File No: 2019/339289  
Your Ref: SSD-6471-Mod-4  
Our Ref: R/2014/13/G

**Art Gallery NSW Expansion Project – Sydney Modern – Modification 4 (SSD-6471-Mod-4)**

I refer to the application to modify the consent for the Art Gallery NSW Expansion Project (“Sydney Modern”). It is noted that the application proposes various modifications to landscaping and the public domain.

Sheet No.
LD_DA_00-02

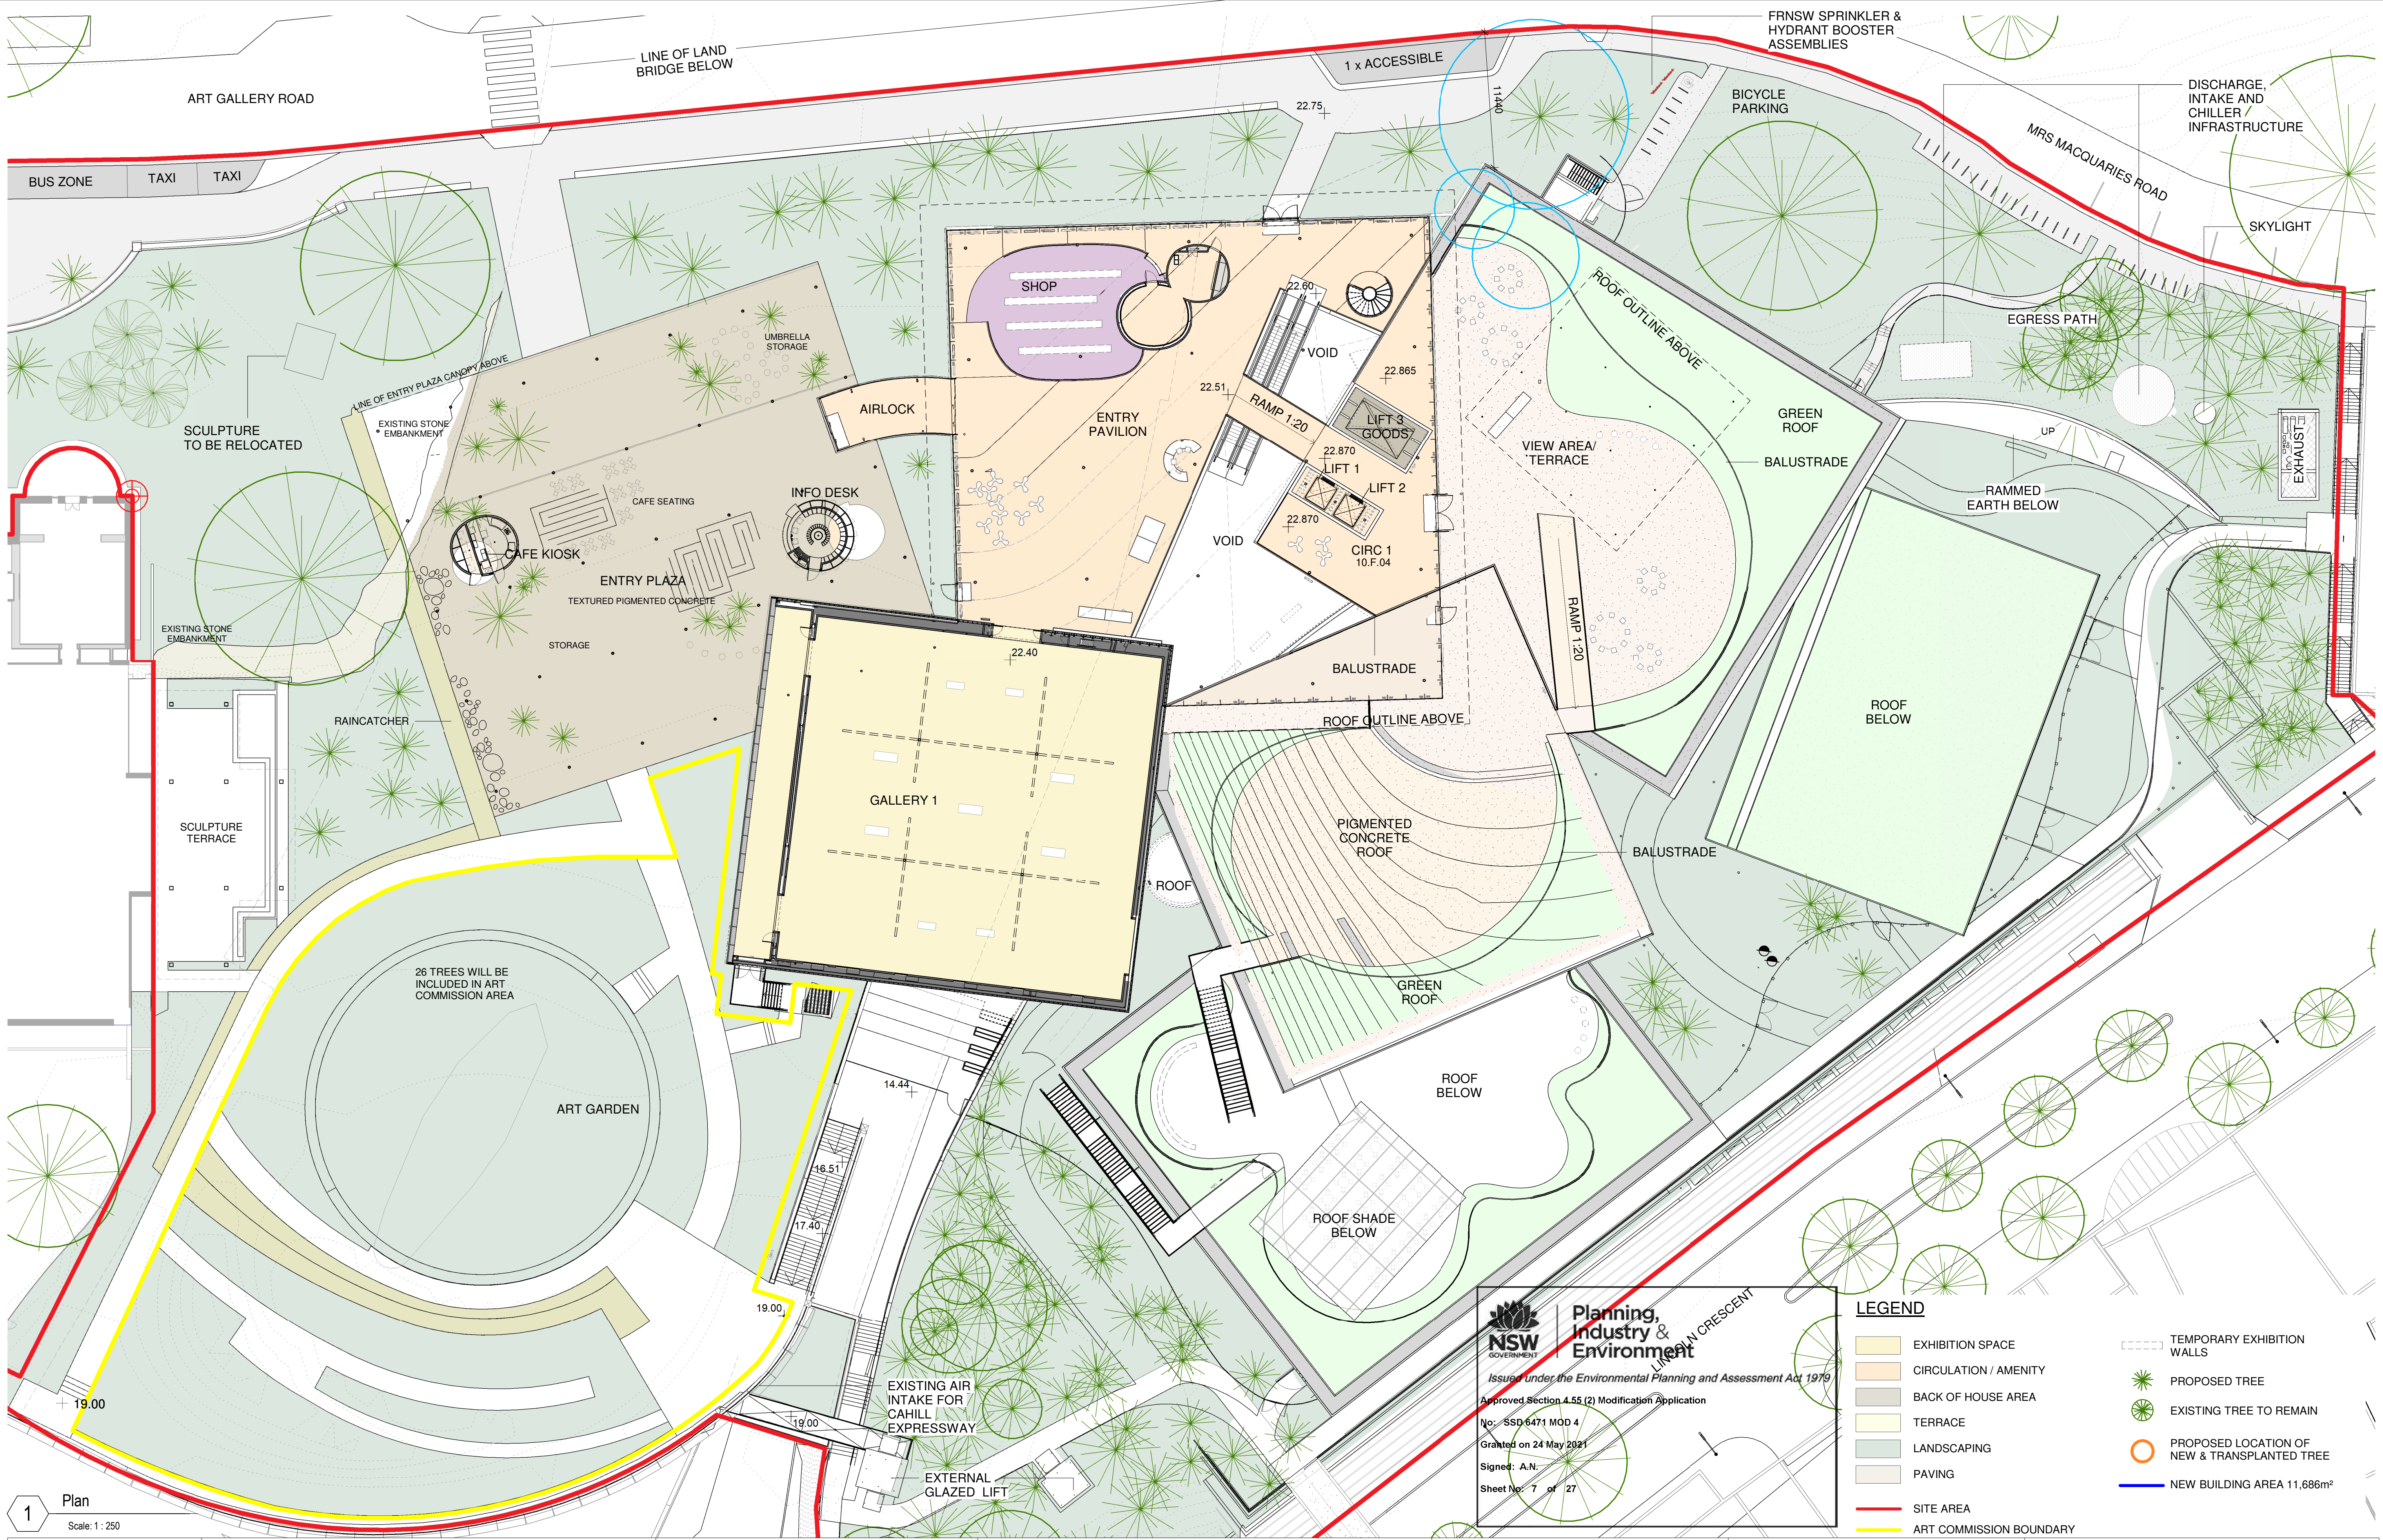
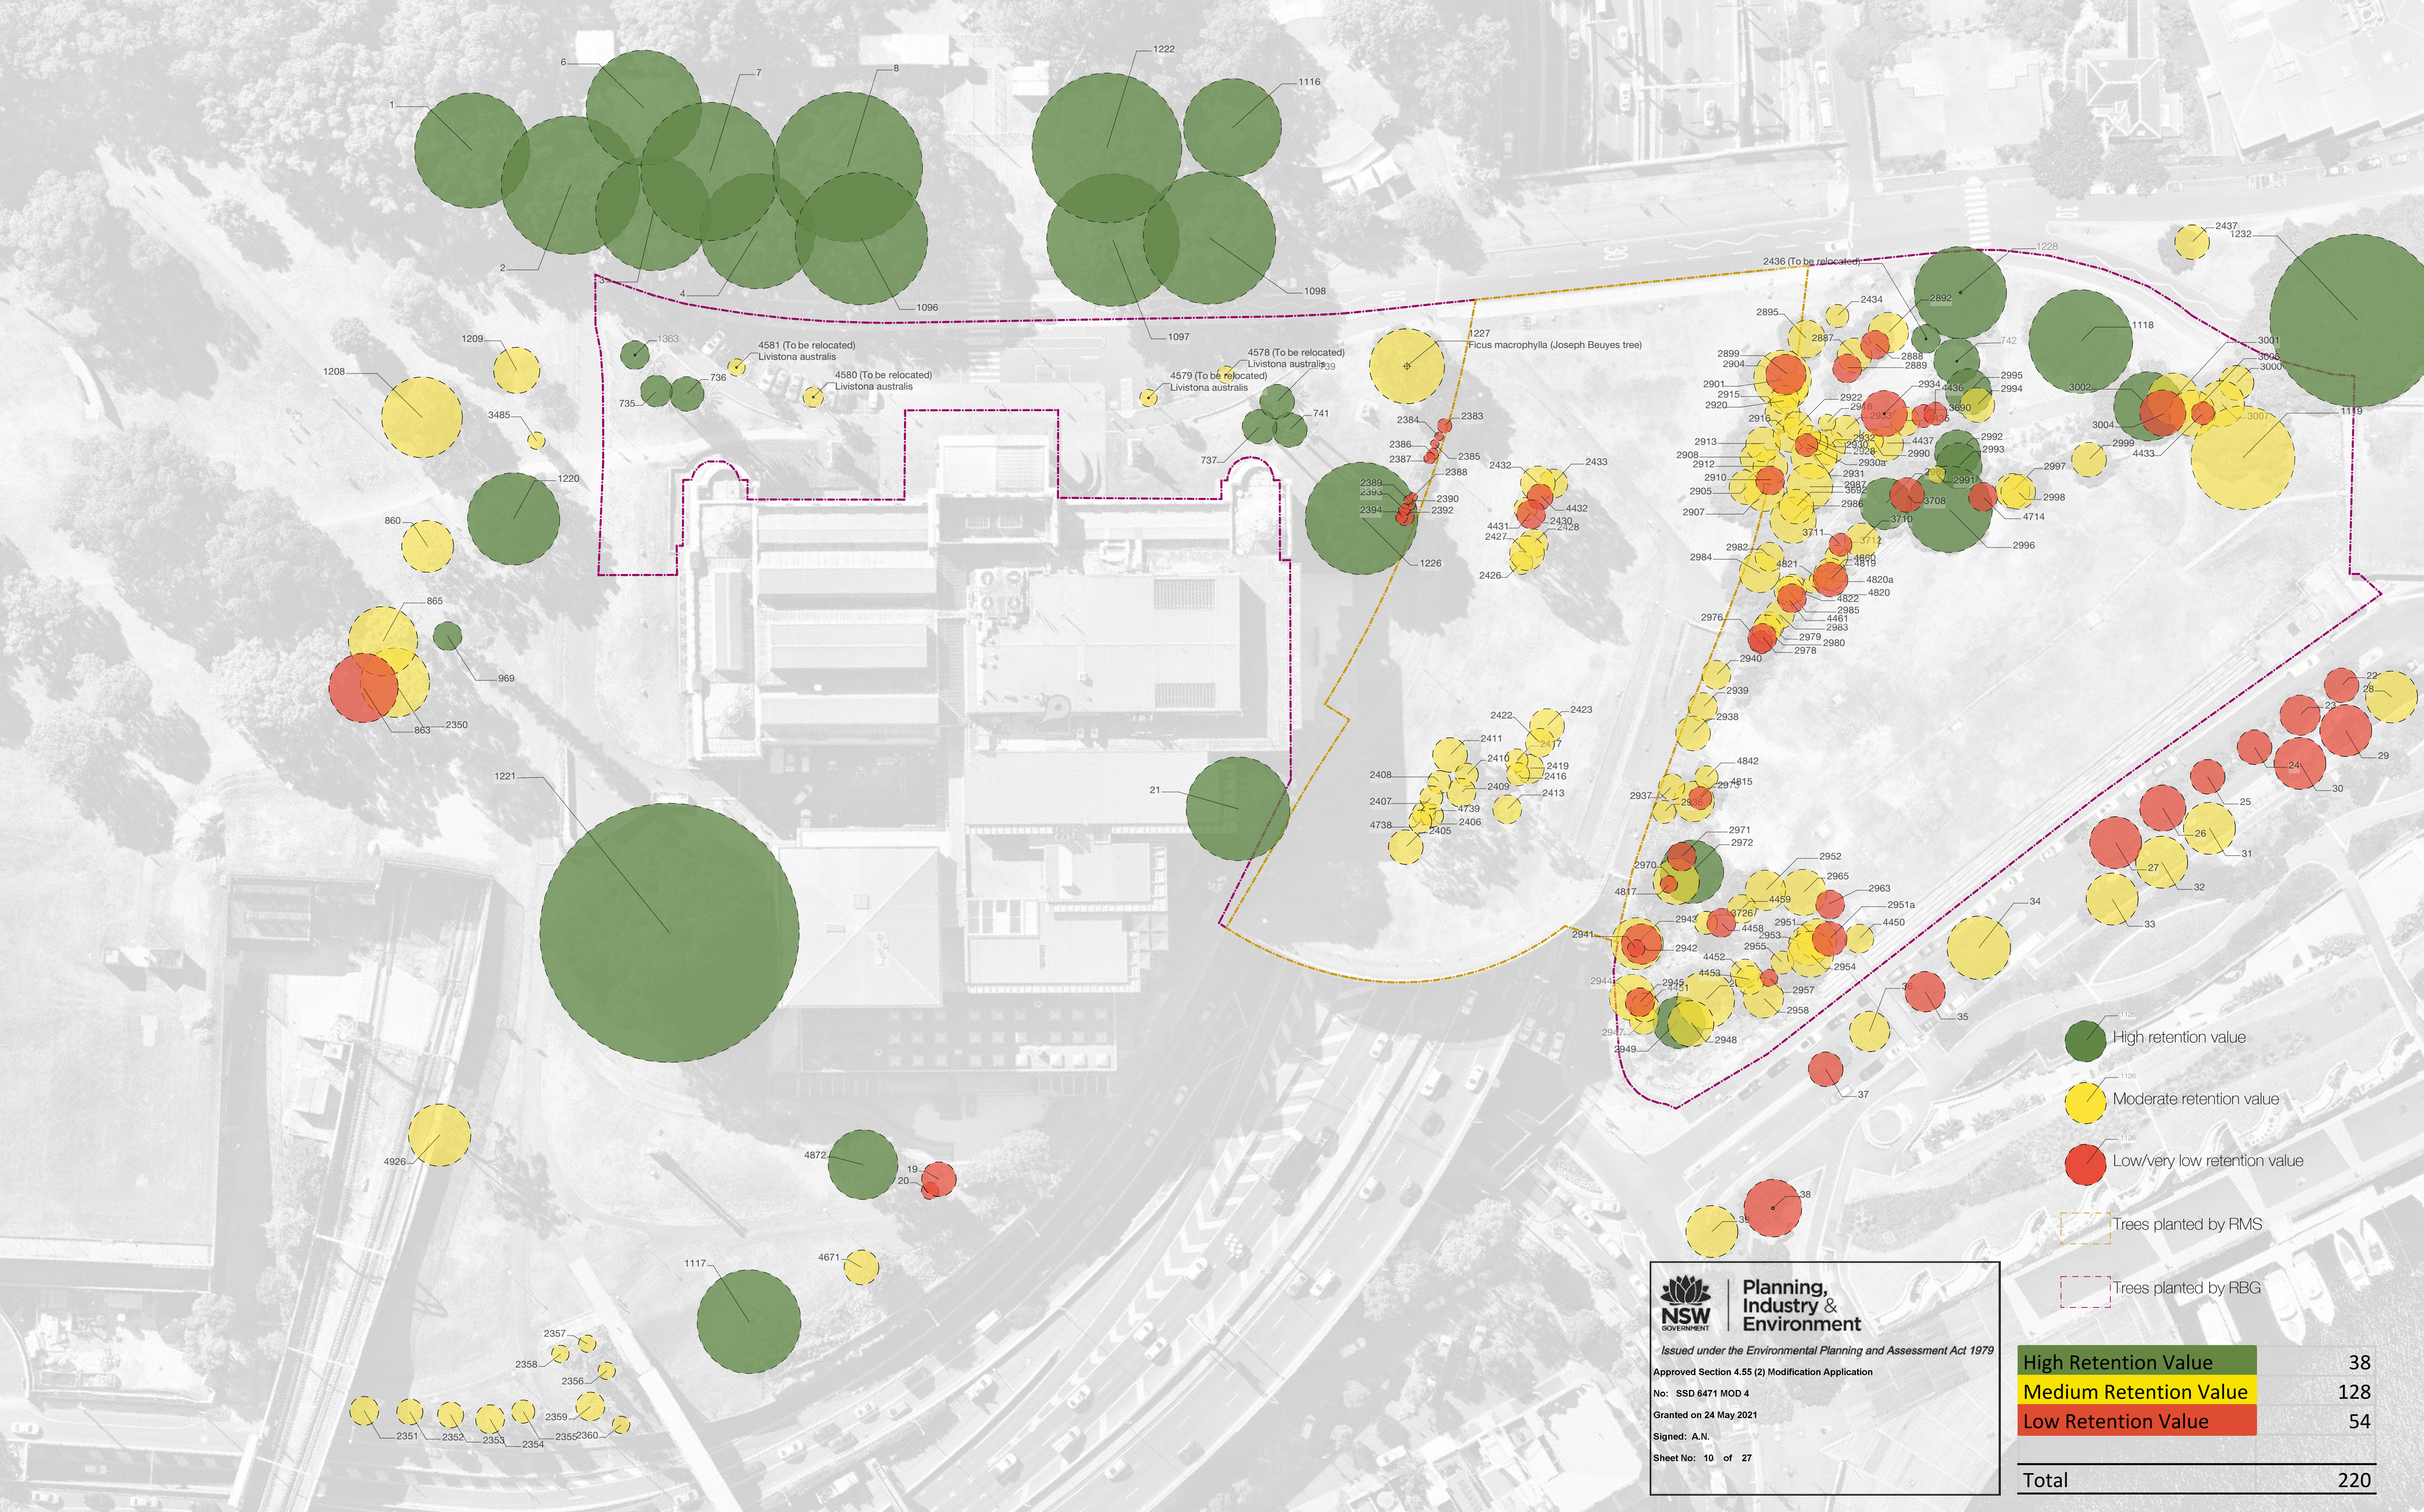
The City also requests further information regarding the 26 new trees to be planted on the land bridge and how the applicant intends to integrate a major art installation

in this location. It is requested that the applicant provides an updated landscape plan that includes the proposed canopy cover percentage over the site.

The majority of the proposed pot sizes are TBC on the landscape plan. These should be finalised before determination of the amendment to ensure appropriately sized trees are selected for the landscape.

Sheet Title
Vernon Curtilage

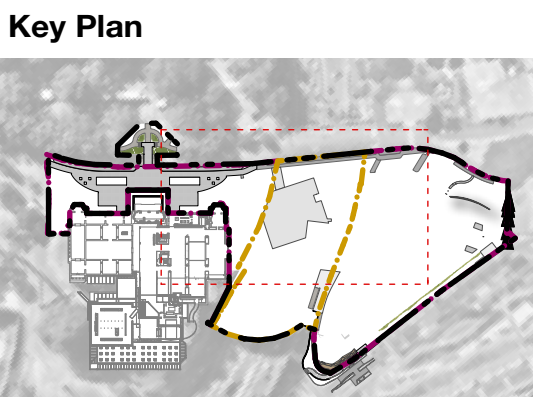
City staff have reviewed the modifications and are generally supportive of the conversion of car parking to public forecourt in front of the existing gallery building. However, the design of the cultural plaza appears cluttered, will constrict mobility and detract from views to and within the heritage site. The following elements are not supported and/or require redesign:

- The reflection pools may be supported if they are inground and flush with existing ground level, similar to the War Memorial.
- The density of trees within the plaza poses an obstruction to views of the existing building from within the site and the public domain.
- The location of the bollards impedes access, and it is unclear if their design is consistent with the City's strategies.
- The remodelled path from the Domain, the impact on the history of the statues and the new entrance walls require further information with regard to heritage impacts, accessibility and landscaping.
